Re: **Popeyes Juan Tabo**
840 Juan Tabo Blvd NE
Traffic Circulation Layout
Engineer's/Architect's Stamp 9-13-24 (K22D035A)

Based upon the information provided in your submittal received 10-2-24, the above referenced plan cannot be approved for Building Permit until the following comments are addressed:

BICYCLE PARKING SPACES DETAIL
SCALE: 1" = 2'

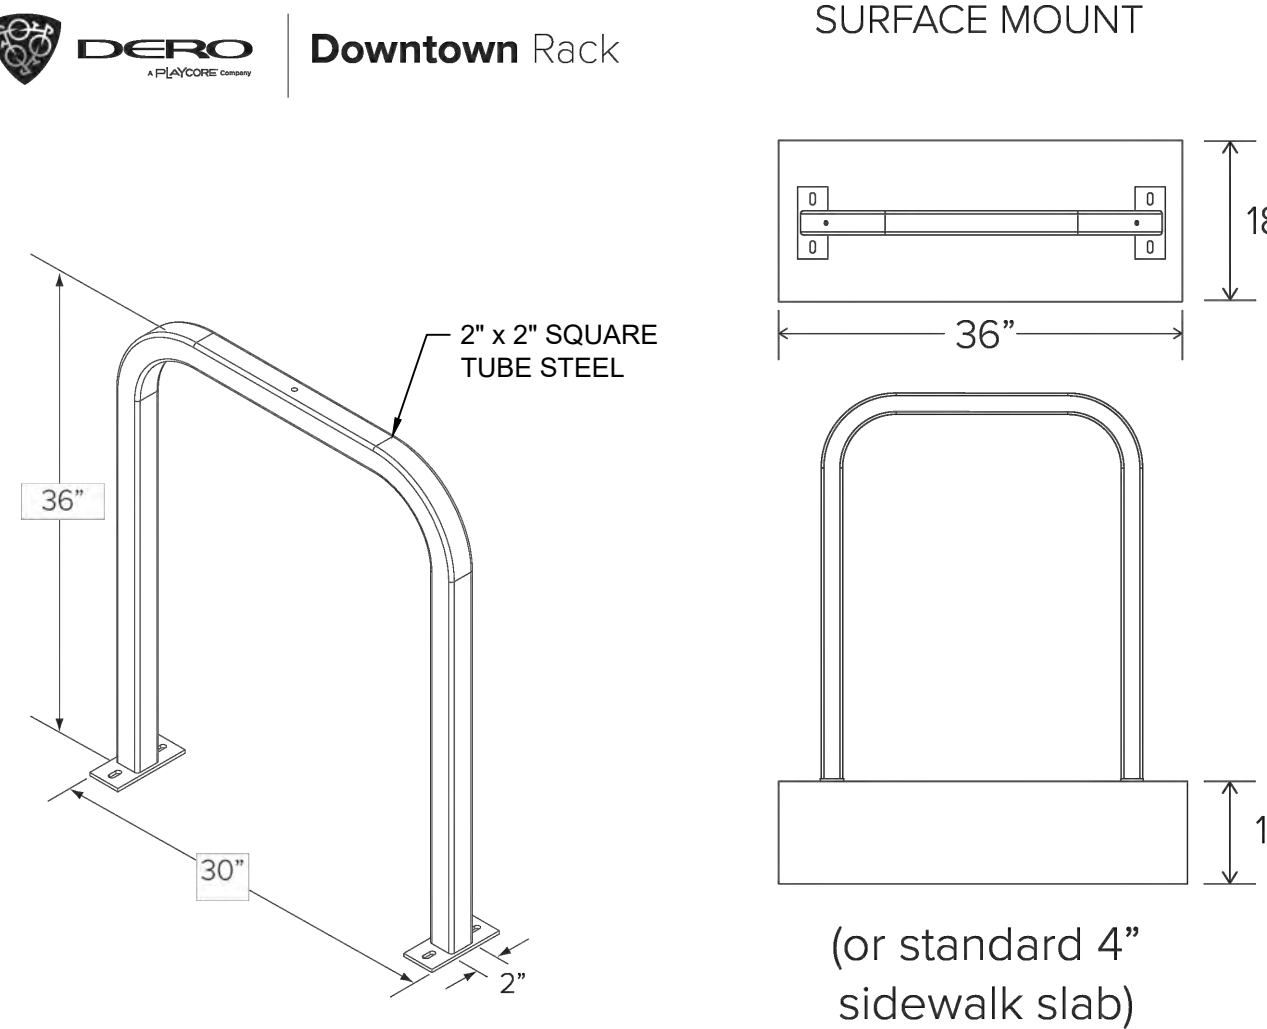
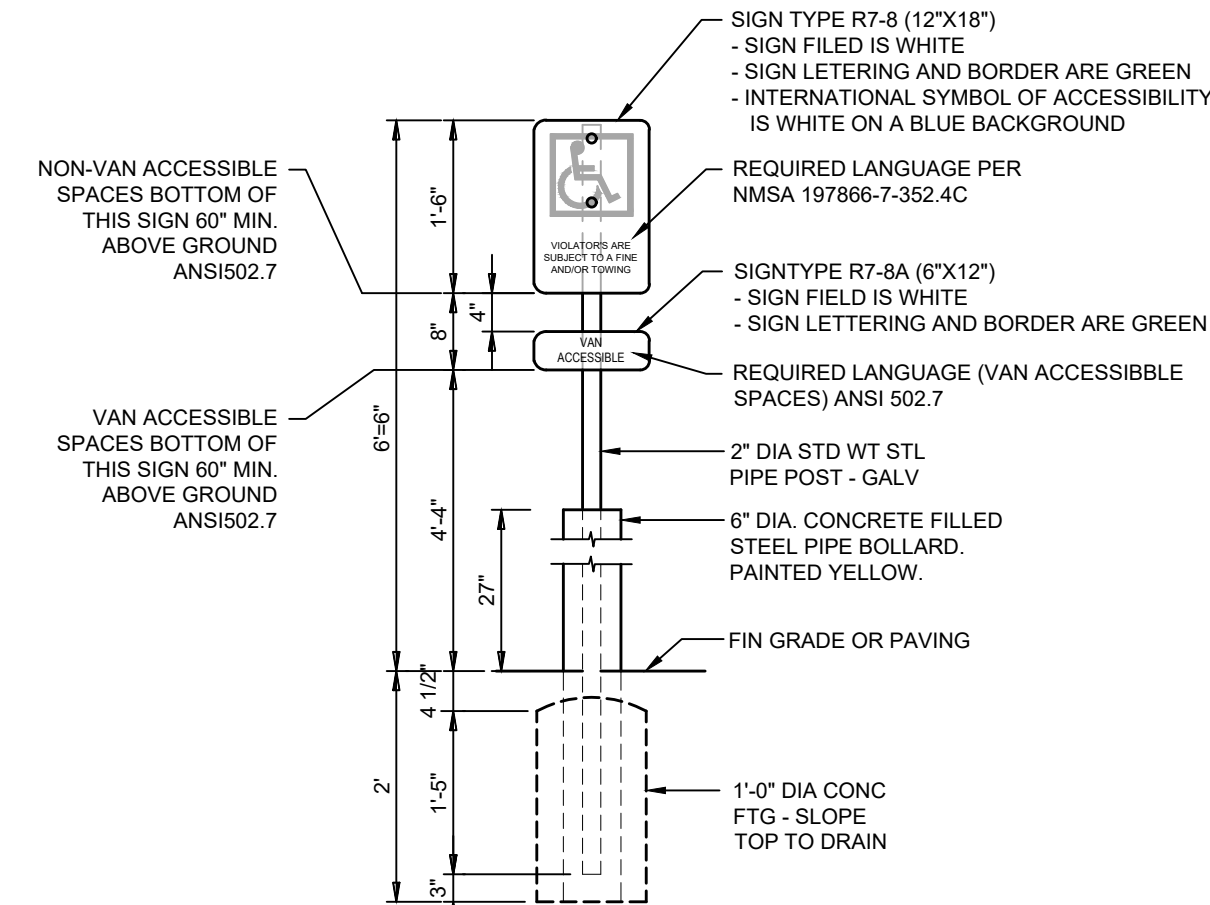
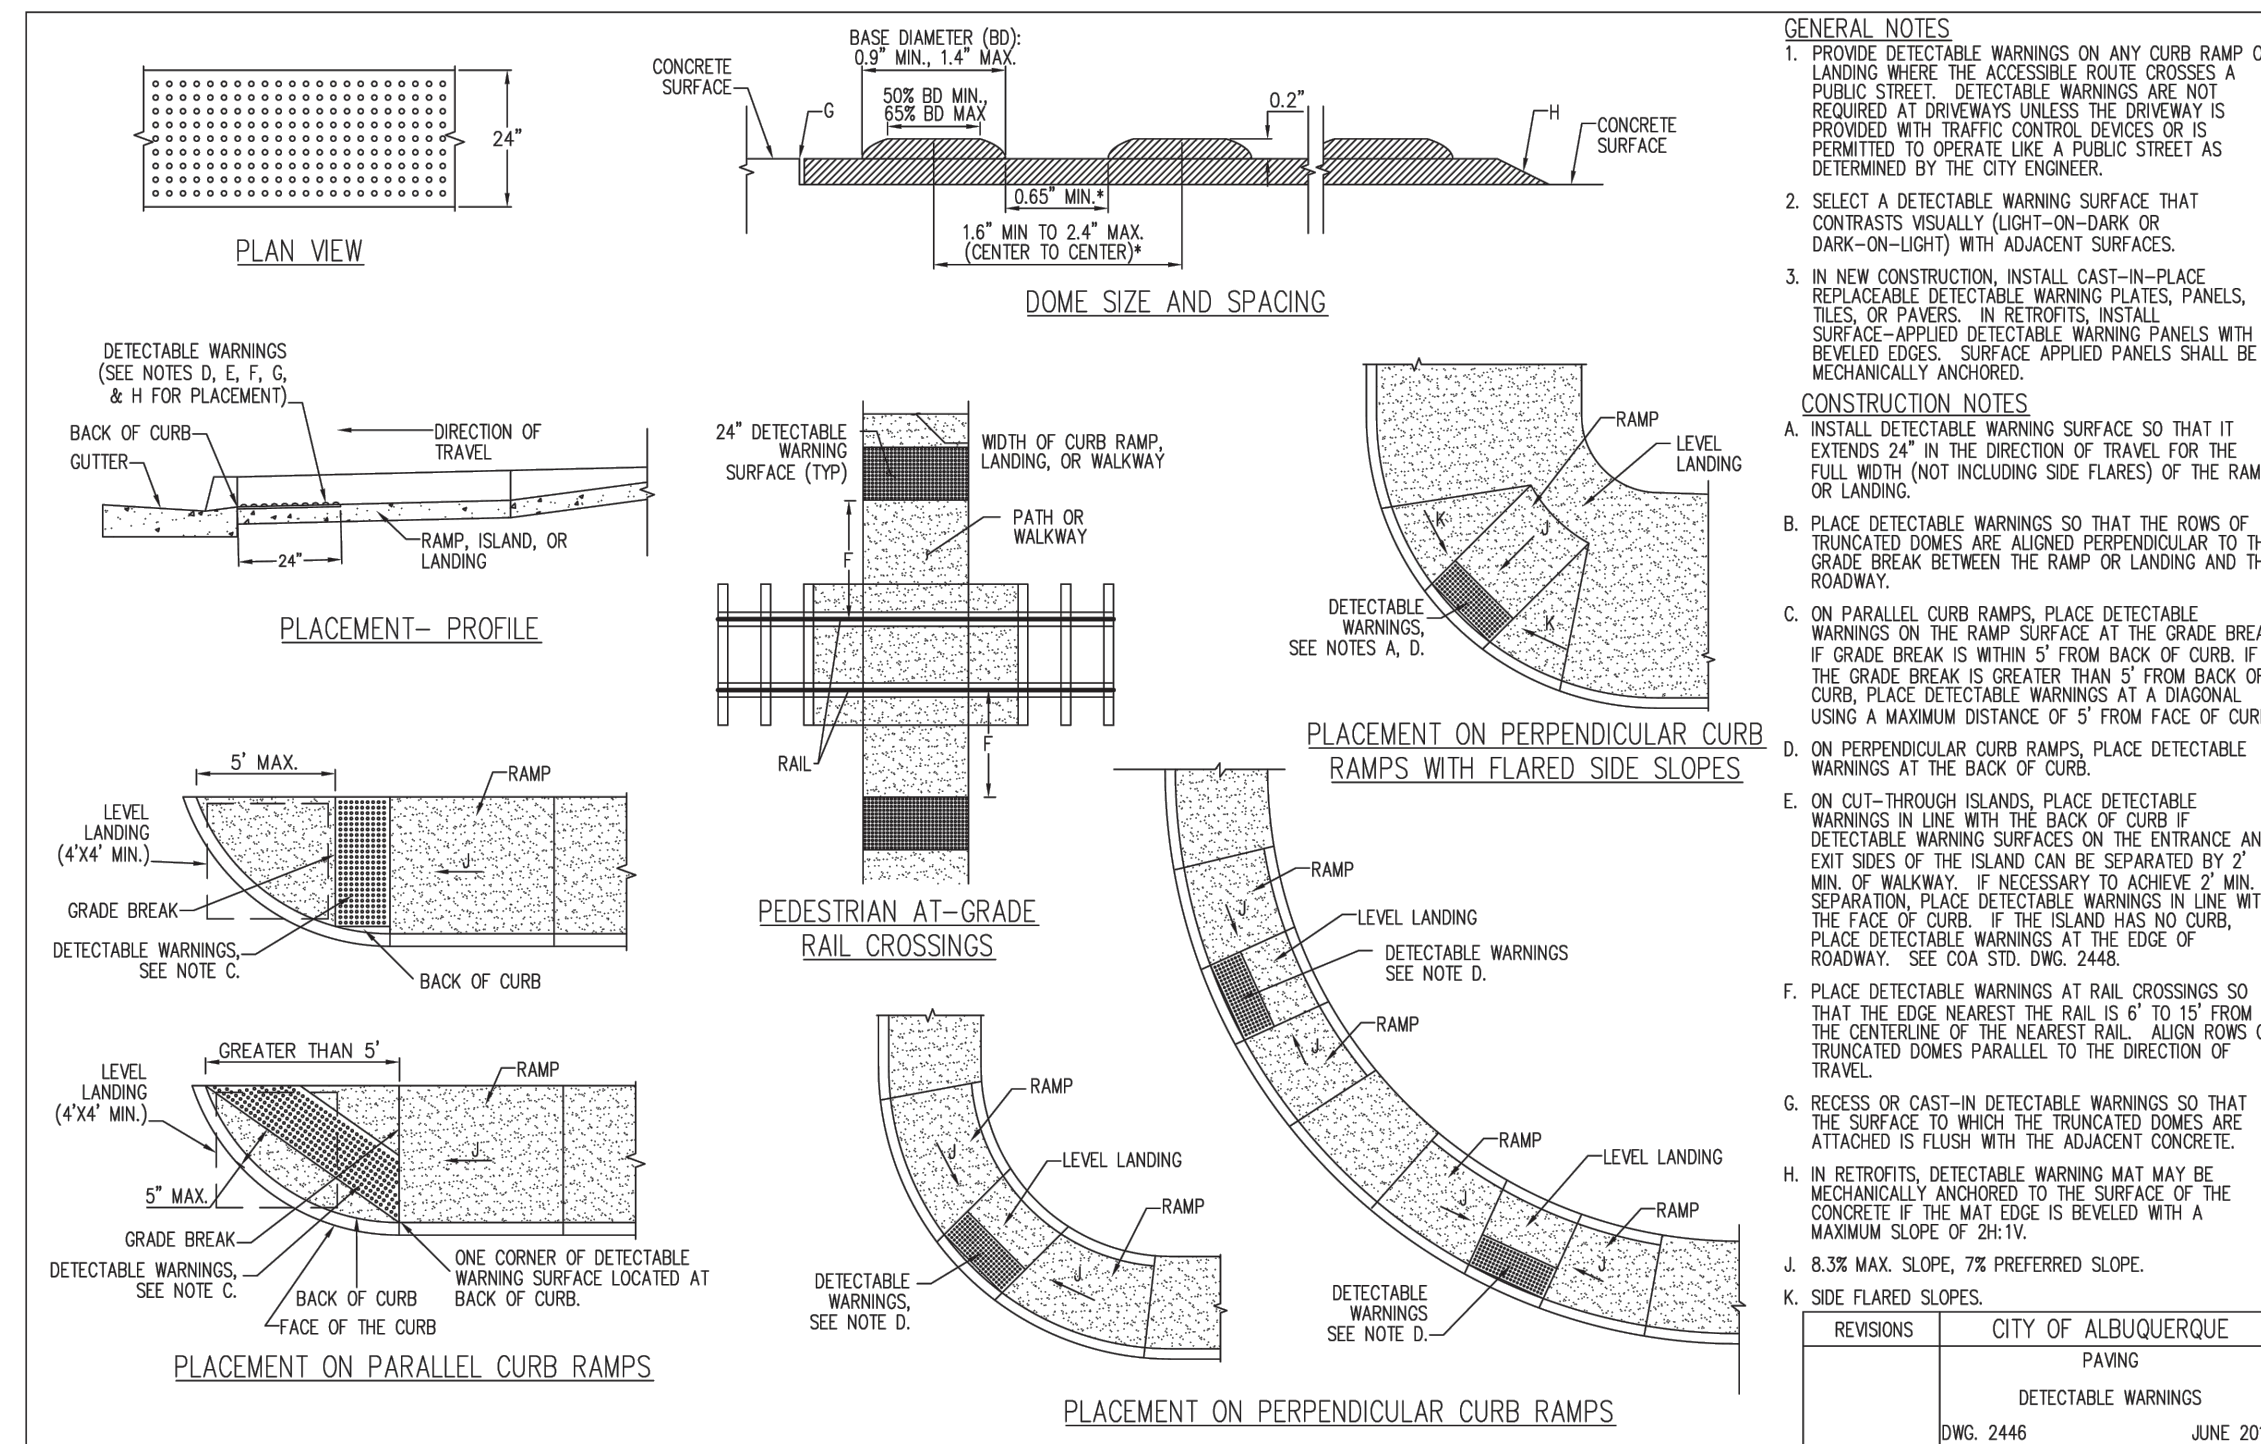
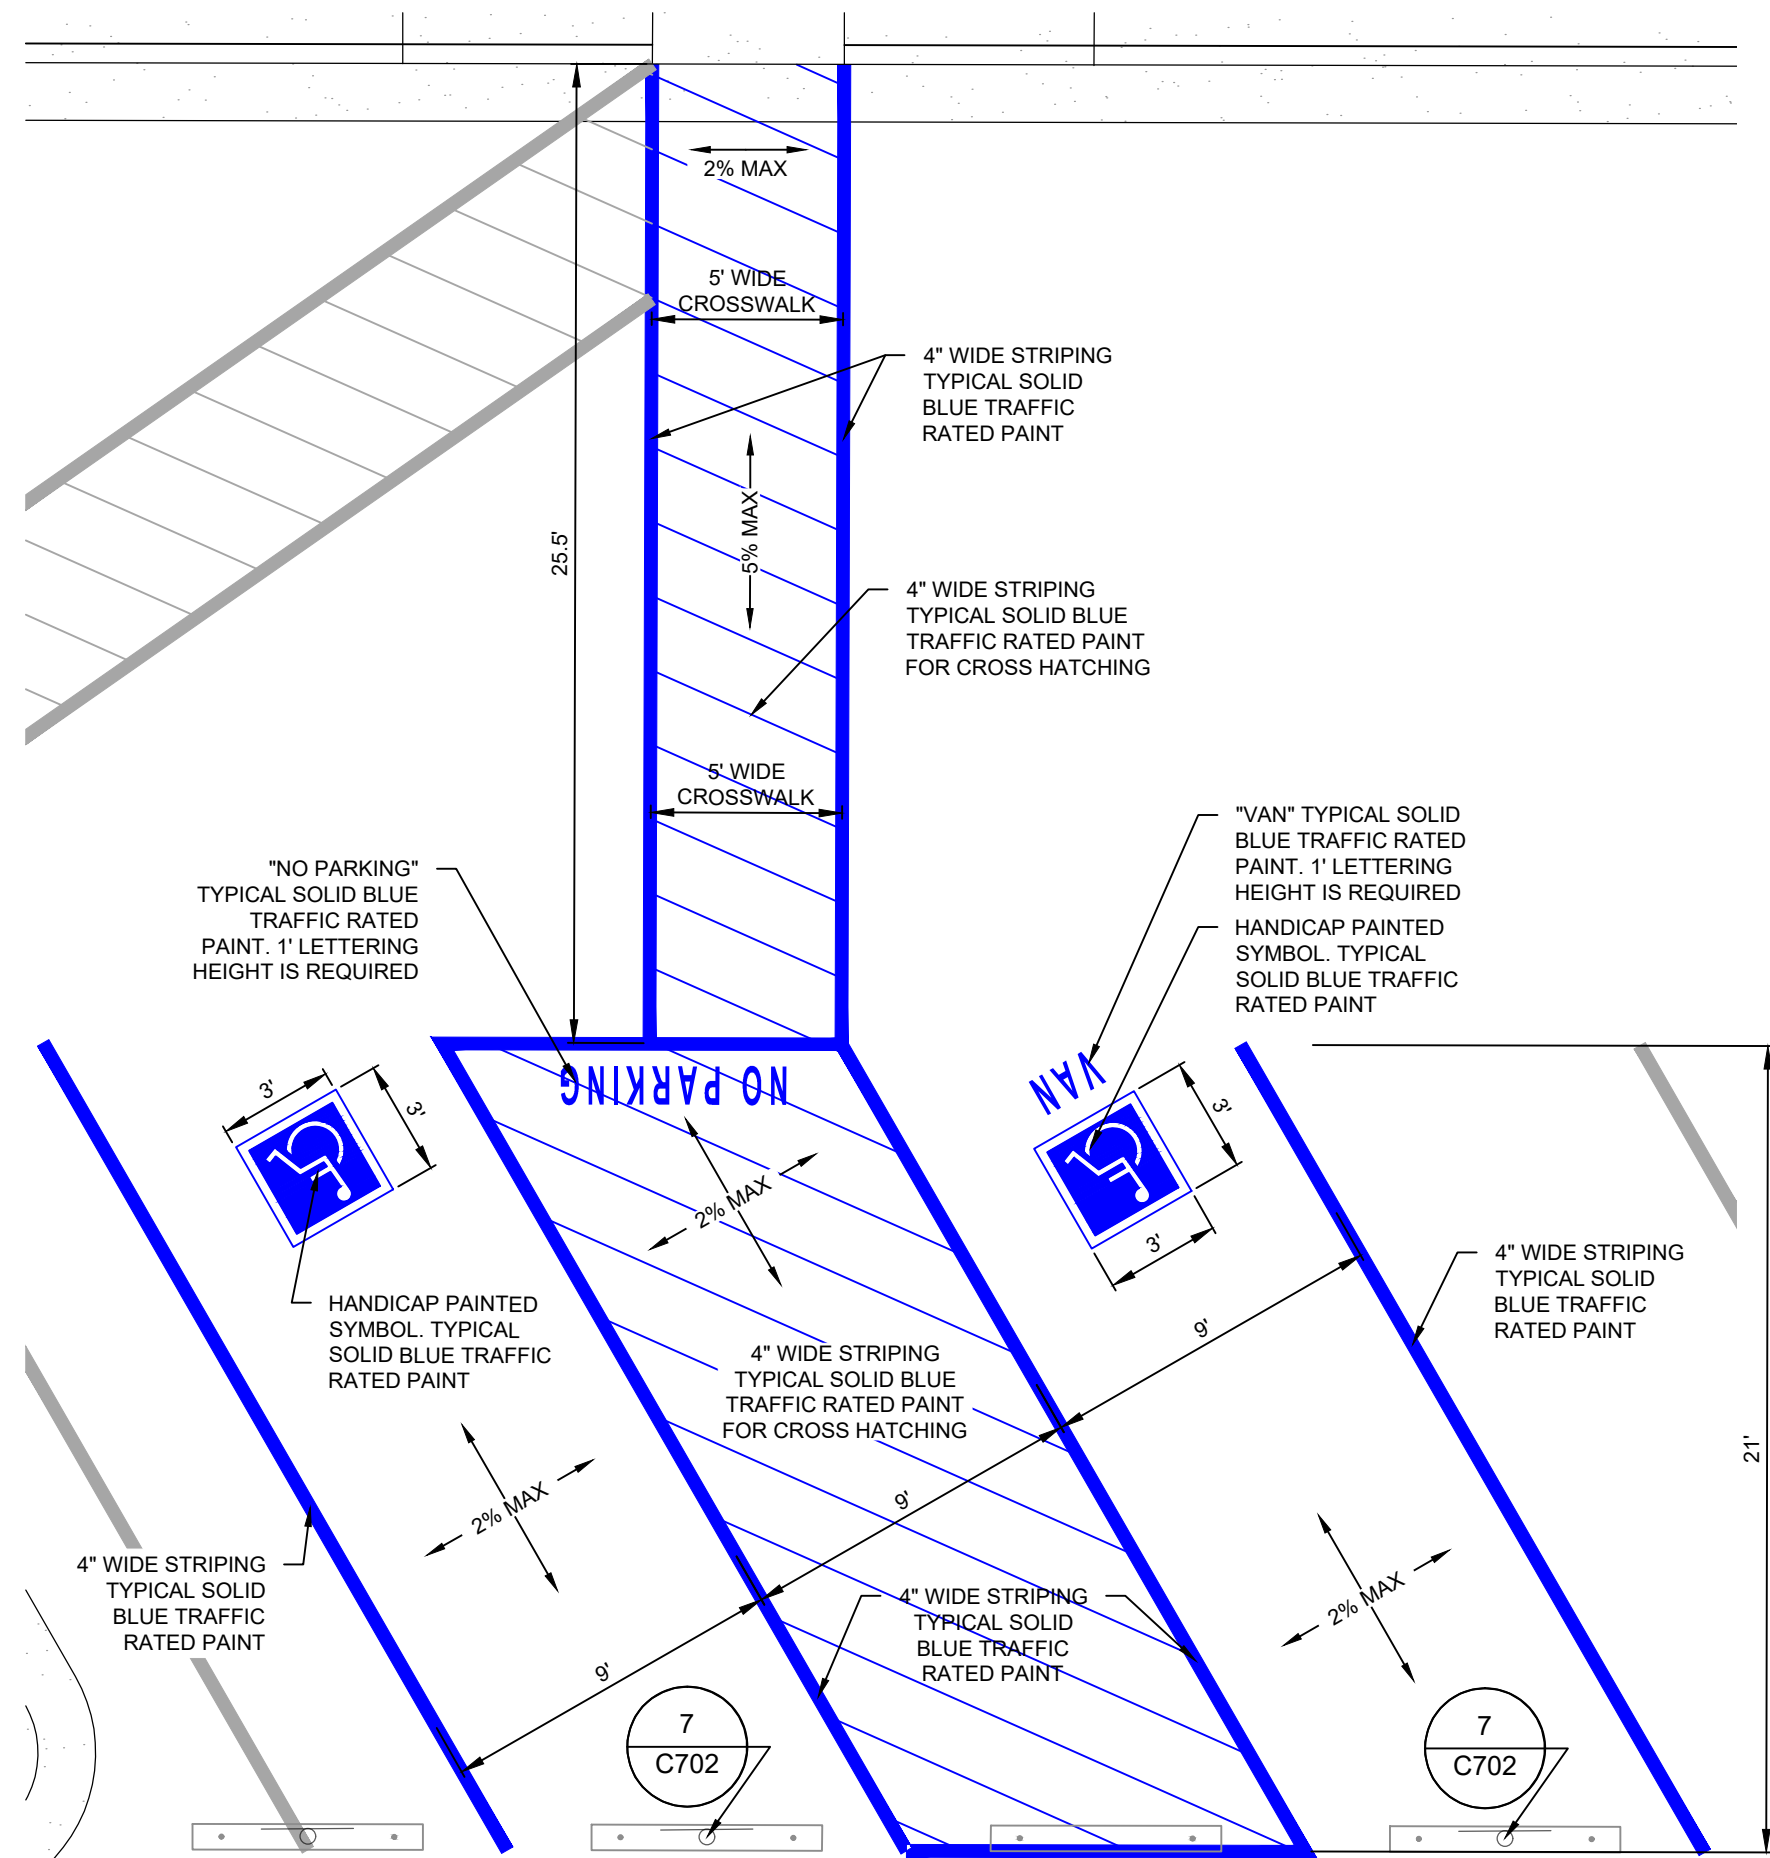
1. Please show a vicinity map showing the location of the development in relation to streets and well known landmarks. **SMA has added vicinity map to TCL sheet C701.**
2. Show all the dimensions for the entrances/exits, drive aisles and any other missing dimensions. **SMA will include dimensional site plan in TCL submittal.**
3. Please list the width and length for all existing and proposed parking spaces. Some dimensions are not shown. **SMA will include dimensional site plan in TCL submittal.**
4. A 1-foot clear zone around the bicycle parking stall shall be provided. **SMA has adjusted the bike parking detail on sheet C702.**
